From: Halford, Colin <colin.halford@sweco.co.uk>
Sent: 21 September 2023 13:47
To: Daniel.Hoare@kent.gov.uk; Gideon.Miller@kent.gov.uk
Cc: Liddell, Martin; Barrell, John; Paing, Yan; David Barker
Subject: FW: FAO - Daniel Hoare & Gideon Miller- Response To Application Number 22/505852/SUB at Land Off Staple Street Hernhill Kent ME13 9HY
Attachments: Response_22-505852-SUB.pdf; 5324-1005 St Details.pdf; 5324-1001 Rev C GA.pdf; 65204882-SWE-ZZ-XX-DR-C-0101-C11 Drainage Layout.pdf; 65204882-SWE-ZZ-XX-DR-C-0100-C04 Drainage Layout.pdf; MD Calcs Report.pdf

Thank you for your response letter, items 1 to 3 as attached dated 24 August 2023 and for your time on the Teams meeting on the 11 September 2023.

Drawing Number: **65204882-SWE-ZZ-XX-DR-C-0101**

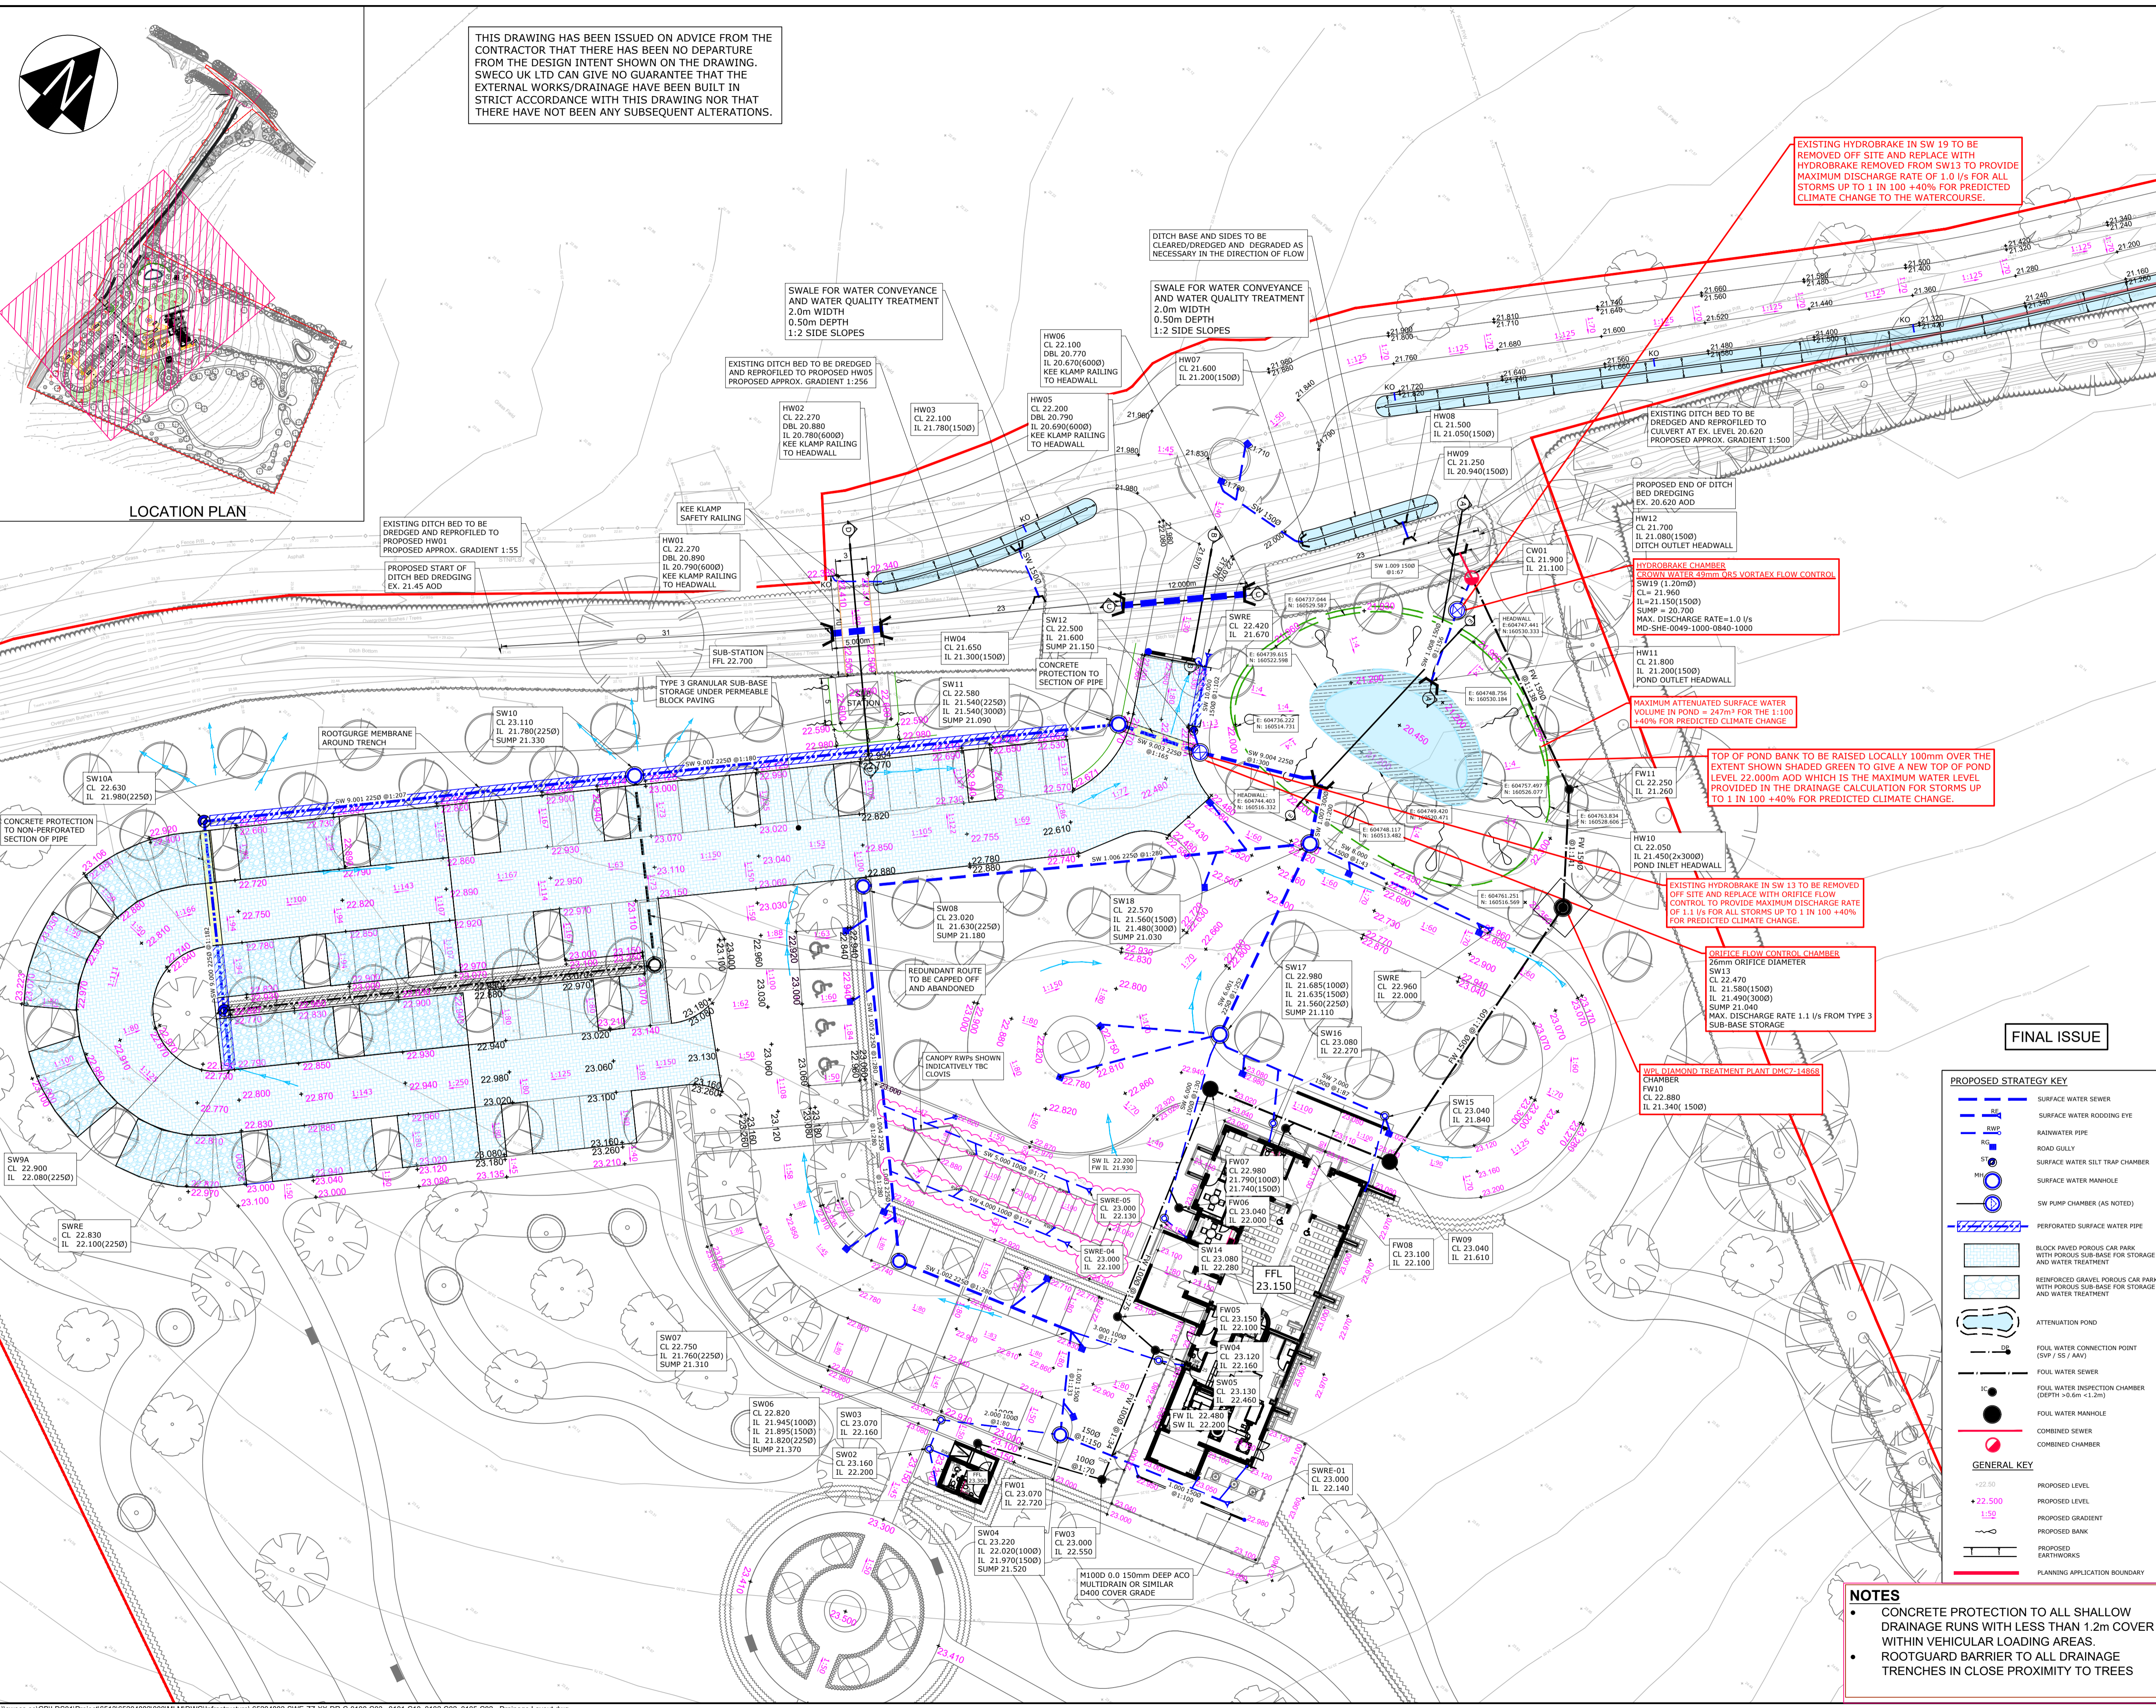
Item 2 – As agreed in the Teams meeting we have reduced the discharge from the site from 2 l/s to 1 l/s by removing the hydrobrake in chamber SW19 (2 l/s) and replacing with hydrobrake from chamber SW13 (1 l/s). The flow control in chamber SW13 will be replaced with an orifice flow control (1.1 l/s). Drainage calculations for the new set up attached showing that the site discharges surface water to the ditch at 1 l/s for storms up to the 1 in 100 year +40% for climate change.

Item 3 – The gully connection is part of the S278 agreement (Sweco were not involved with the S278 works). The gully outfall location was changed from the ditch / swale, as shown on the attached drawing, to the pond to achieve a gravity discharge.
